From: Laura Gibbons <Laura.Gibbons@arun.gov.uk>
Sent: 26 October 2021 13:53
To: Planning.Responses <Planning.Responses@arun.gov.uk>
Cc: Michael Eastham <Michael.Eastham@arun.gov.uk>
Subject: RE: Planning Consultation on: A/188/21/DOC

Application No: A/188/21/DOC

Site Address: Land at Dappers Lane Angmering Littlehampton

Description of Works: Approval of details reserved by condition imposed under ref A/76/20/PL relating to Condition Nos 17 - existing & proposed ground levels, 18 - surface water drainage, 19 - maintenance & management of surface water drainage, 21 - discharge flows to watercourses and 22 - foul drainage system

Project
Attenuation Basin Cross Sections
Sheet 1 of 2

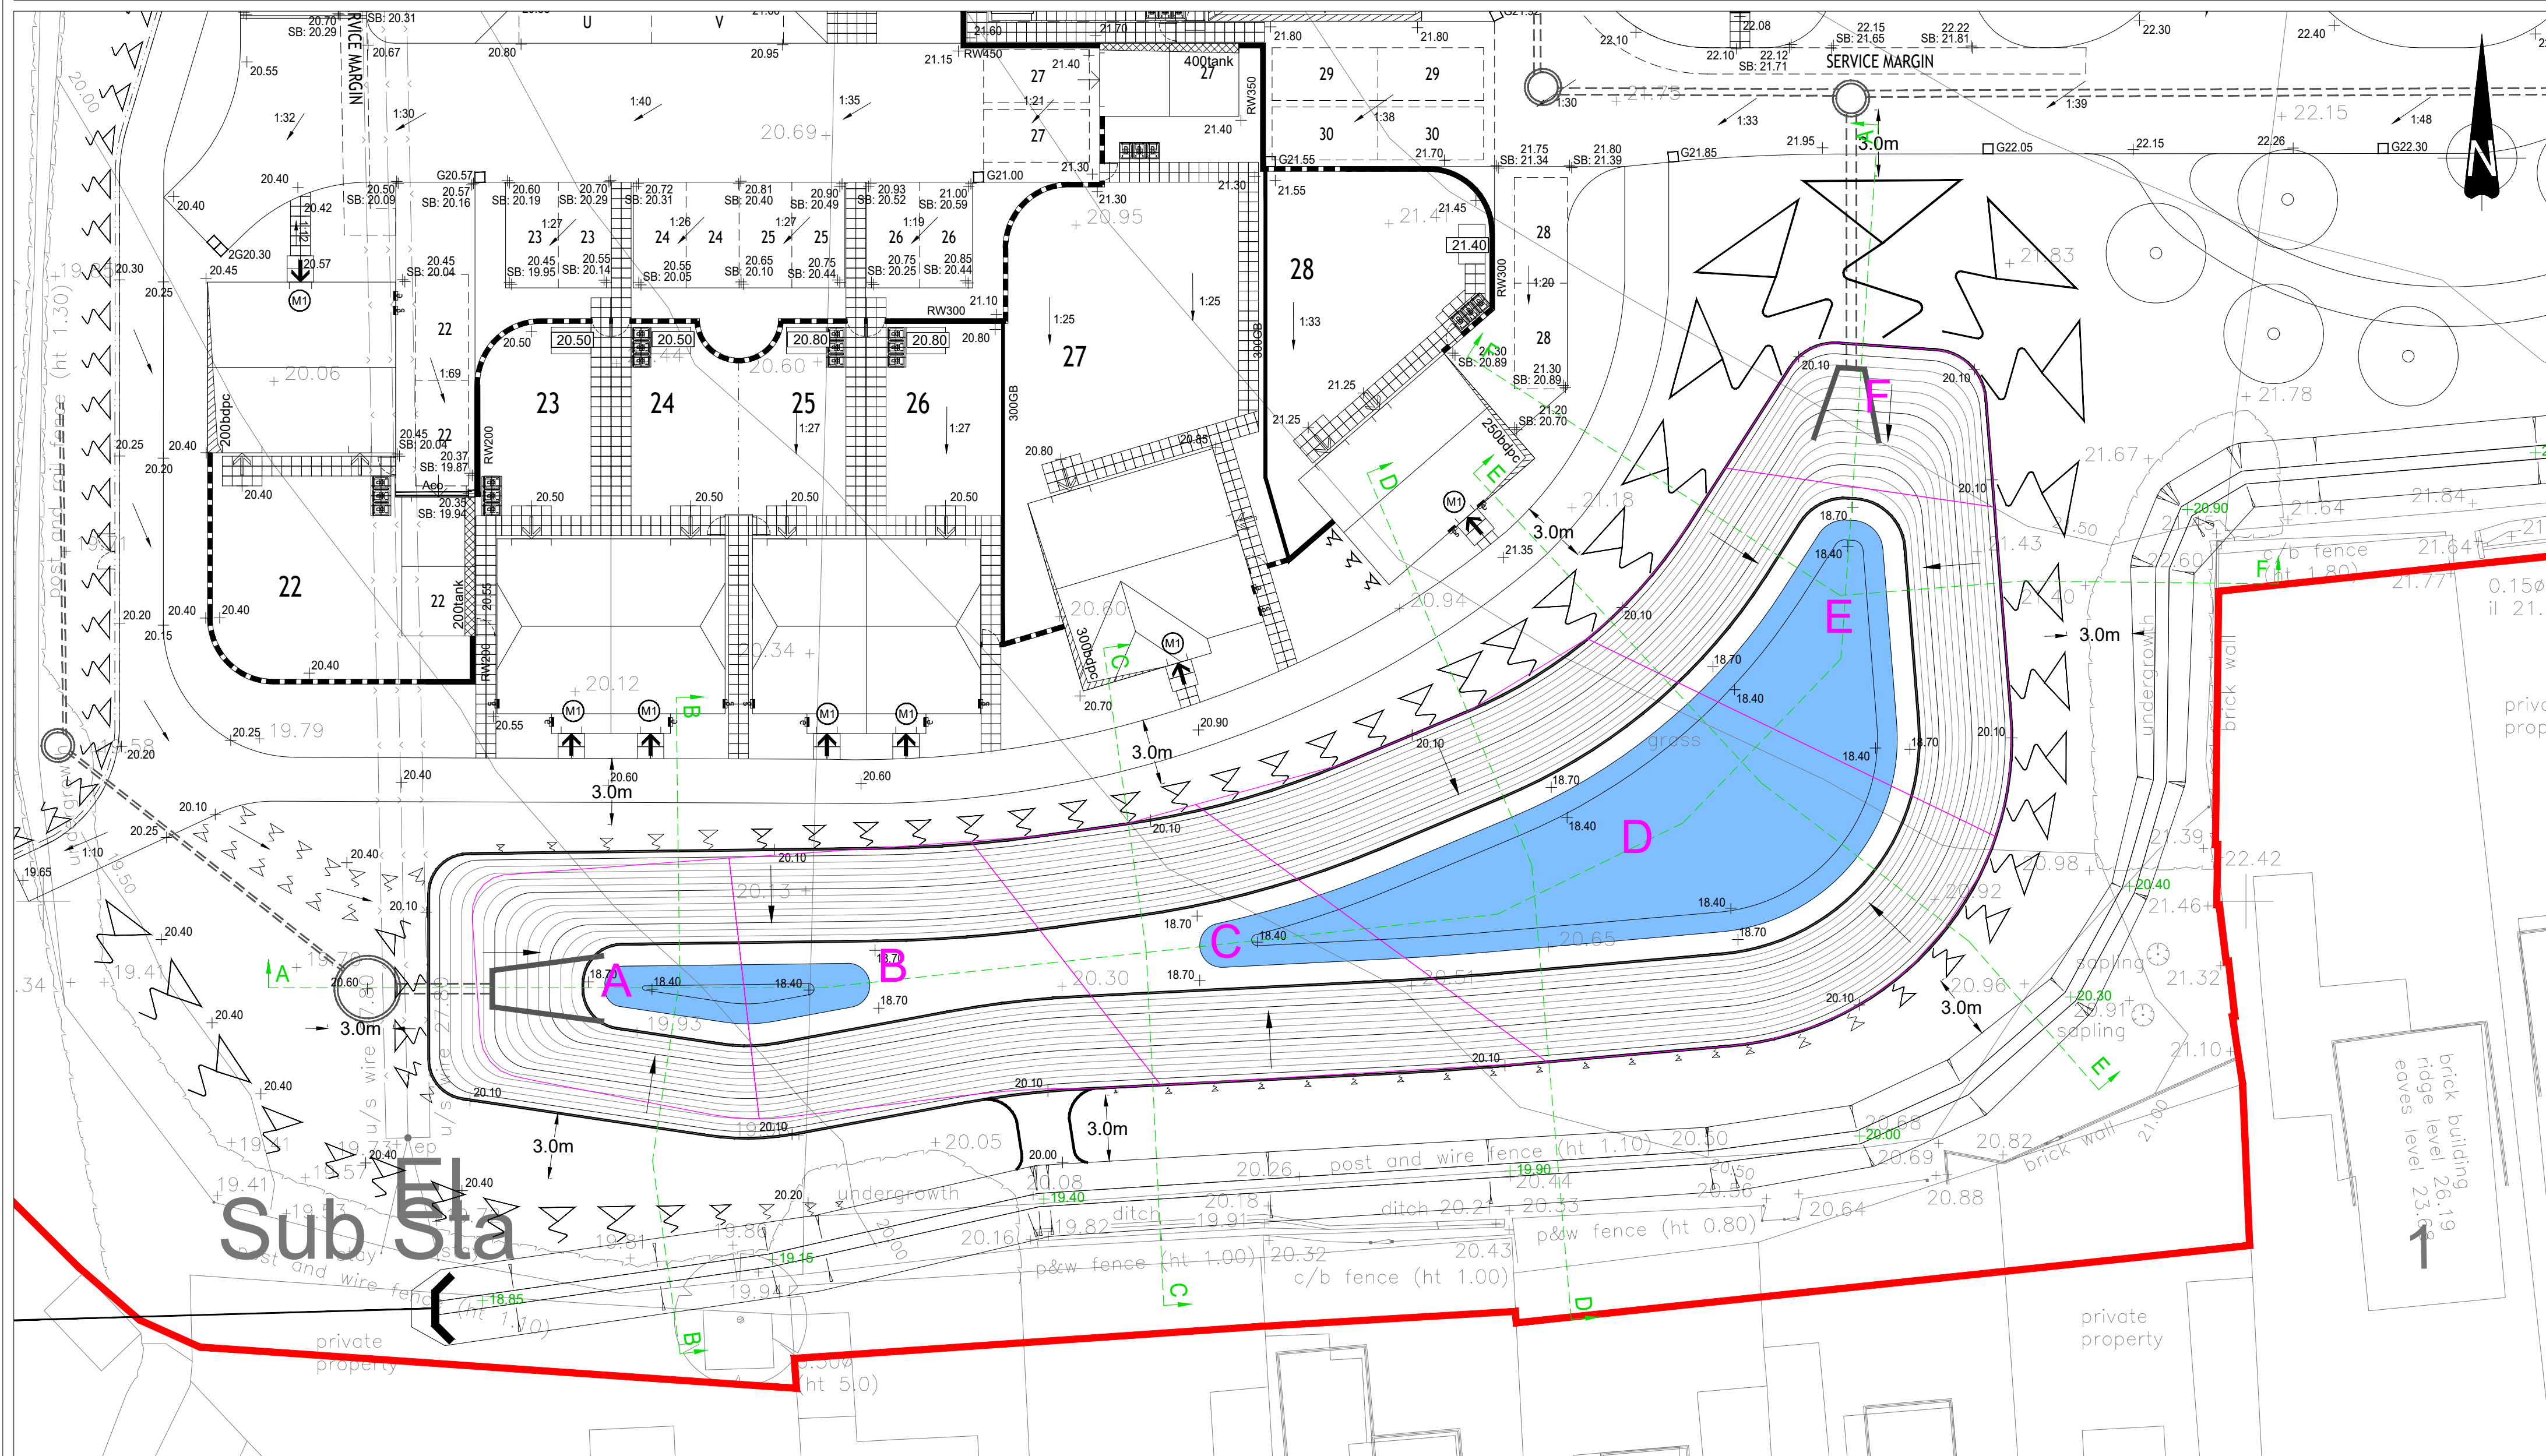
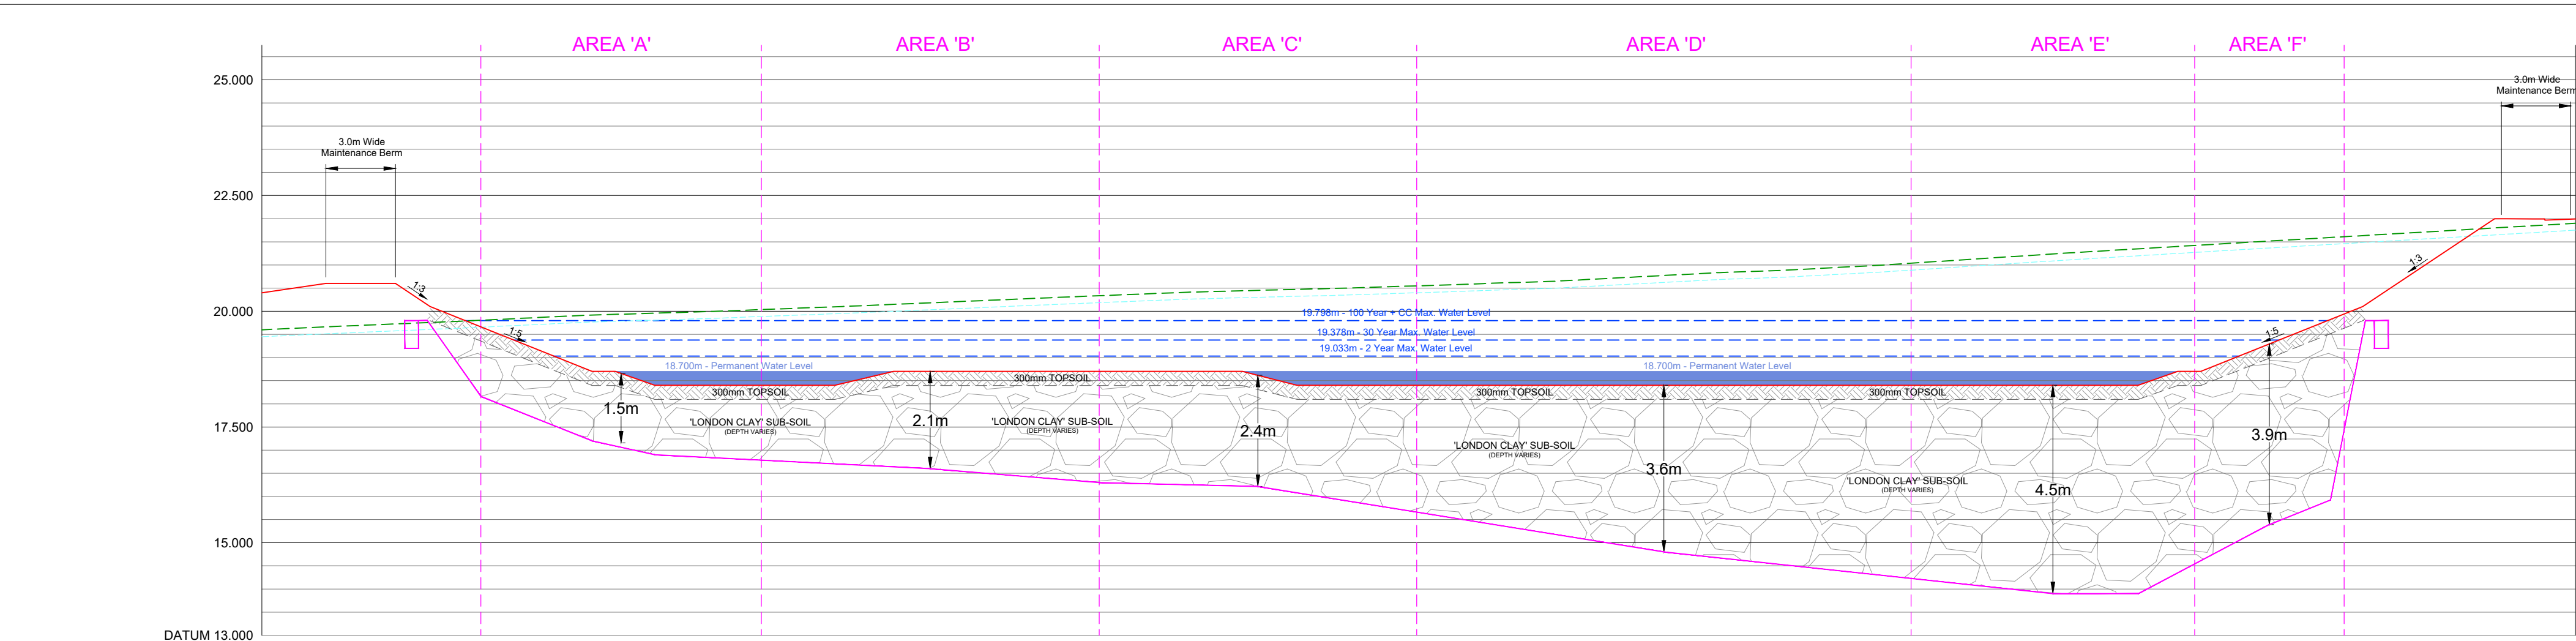
The sketch provided does not clearly show batter extents. However, one of the sump locations is proposed within the proposed ditch extent. There is currently a culvert here. Furthermore, the additional fence line shown for excavation is shown the other side of the ordinary watercourse. As proposals currently stand it is apparent that it will not be possible to excavate the required depth here without bunding the watercourse and temporarily removing a significant length. This is unacceptable.

The method statement provided includes no details of the proposed batter. Assuming this will be a standard 1:3 it is apparent that there is inadequate room on site to construct proposals with just a batter. For example, proposals are

for the impermeable liner to be at circa 13.8m AOD, where existing ground levels are 21.5m. This means an excavation depth of 7.7m, which would require 23m horizontal distance, at most there appears to be approximately 12m available here (ignoring the culvert and 6m distance between batter bank and fence line). Further to the south of the basin, excavation depths of 6m are required, with distances of circa 10m available (ignoring the culvert and 6m distance between batter bank and fence line) for the required 18m horizontal distance.
